**Department of Climate Change, Energy, the Environment  
and Water**

Our ref: OUT24/18232

**Subject: Yorktown Parade and Fitzgerald Avenue, Maroubra Affordable Housing  
Redevelopment (SSD-71454960) – Environmental Impact Statement**

# Detailed advice regarding the Yorktown Parade and Fitzgerald Avenue, Maroubra Affordable Housing Redevelopment (SSD-71454960) – EIS

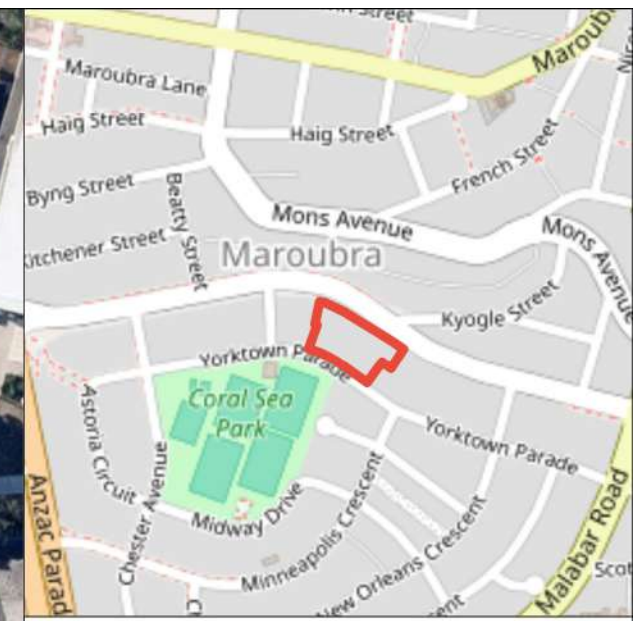
Department of Planning, Housing and Infrastructure requests the proponent to clarify the potential for groundwater interception, and should this be required, quantify the maximum annual volume of water take due to aquifer interference activities. The proponent will also need to demonstrate the ability to acquire sufficient water entitlement to account for water take, unless an exemption applies, or where it can be demonstrated that aquifer interference is not to occur.

The EIS documentation has inconsistencies in the requirement for aquifer interference that require clarification. Section 7.11 of the main Environmental Impact Statement (EIS) states:

However, the Geotechnical Investigation (Appendix W) states that a maximum basement bulk excavation of 5.0m below surface is required, and that the ground conditions include loose sands with water seepage and the need for water to be managed during construction. Further clarification is required to confirm the potential for aquifer interference and the requirement for water licensing.

Department of Planning, Housing and Infrastructure requests the proponent to ensure a water access licence (WAL) is obtained to account for the maximum predicted water take for construction and operation activities unless an exemption applies under the Water Management (General) Regulation 2018.
